Appendix A - Conservation Officer comments

14/01552/F and 14/01601/LB

Chancel Cottage, Fir Lane, Steeple Aston

Internal alterations and removal of attached outbuilding to enable new extension

Fig.29 - Proposed First Floor Plan

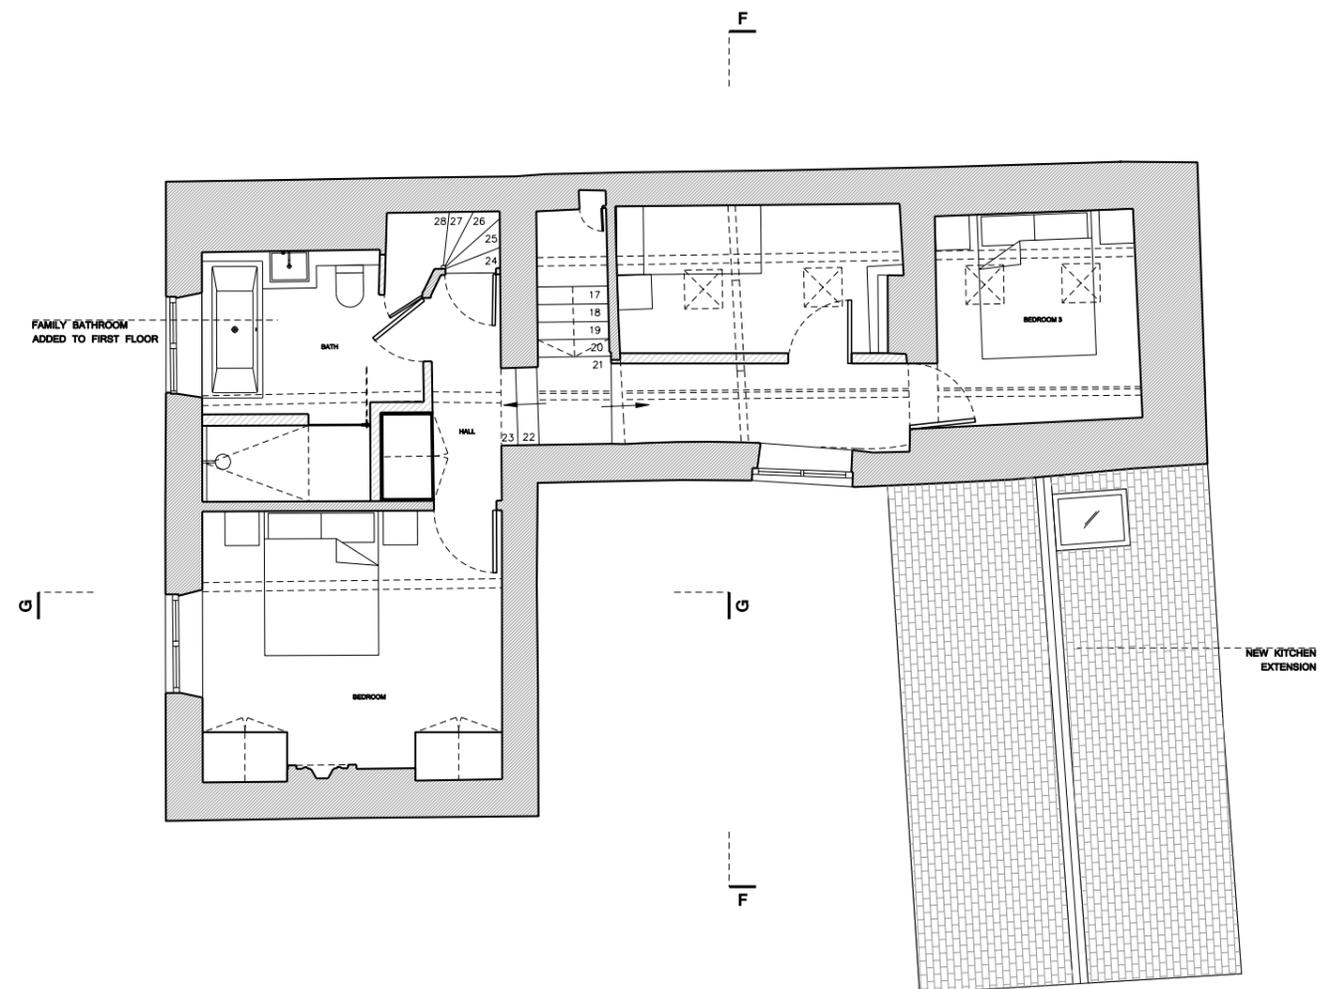
There is, however, the proposal to form an additional doorway at first floor level. The doorway is between the original stable range and the later 19th century addition, which was constructed as a physically separate structure. The ground floor area of the building has been brought into domestic usage, but the first floor area remains unconverted and unused. There is evidence of a former opening at first floor level which has since been blocked up. There would be some harm to the significance of the site if this element of the building were to be converted, but this would need to be weighed against the public benefit of bringing this section of the building into use with the associated benefits of better maintenance.

Dormers are not a characteristic element of simple, vernacular cottages such as this one and will have an aggrandising effect at the rear of the property. There are no objections to the use of the space and an existing stairway leads up to the attic level. The proposal for roof lights, which are flush to the roof is a compromise which allows light into the space. It should be clear, however, that if further alterations are required to enable the space to be used as a bedroom due to building control requirements these may not be forthcoming. The property could function as a three bedroomed family home with additional, ancillary space to be used as office, study or playroom. The proposed dormers are considered to cause harm to the significance of the historic building and the public benefits are not considered to outweigh this harm.

Chancel Cottage - Proposed West Elevation

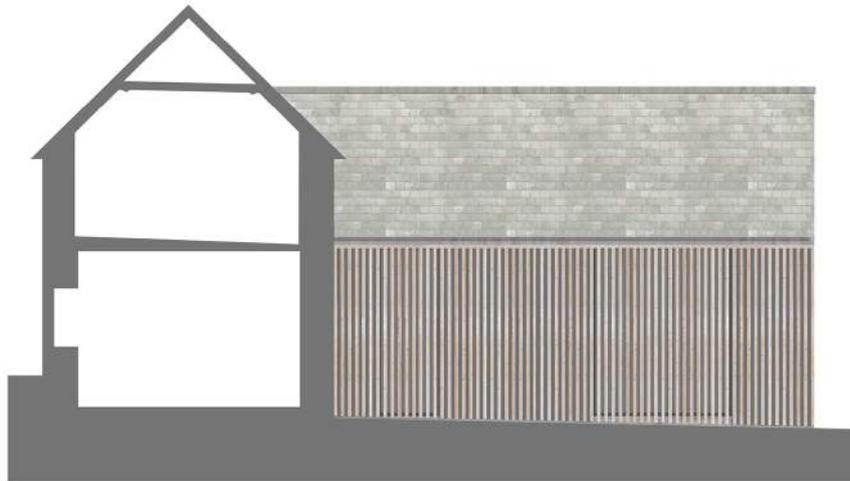
There are significant concerns with the use of timber boarding in this context. The use of timber or weather-boarding appears to be the latest 'trend' in the district, but does not have historic precedent in the locality. Weather-boarding is historically reserved for detached outbuildings or specific functions in relation to canal side buildings and mill buildings. The proposed extension is not an outbuilding, but a large extension which is physically joined to the property. There are also long term maintenance concerns, particularly with untreated timbers whereby there can be varied

weathering depending on localised conditions. It is important to consider the visual appearance and maintenance issues for the property in the medium to long term. The proposed use of timber boarding on an extension (as opposed to outbuilding) is considered to cause harm to the character and appearance of the conservation area and the setting of the listed building. There is not perceived to be any public benefit to outweigh this harm.
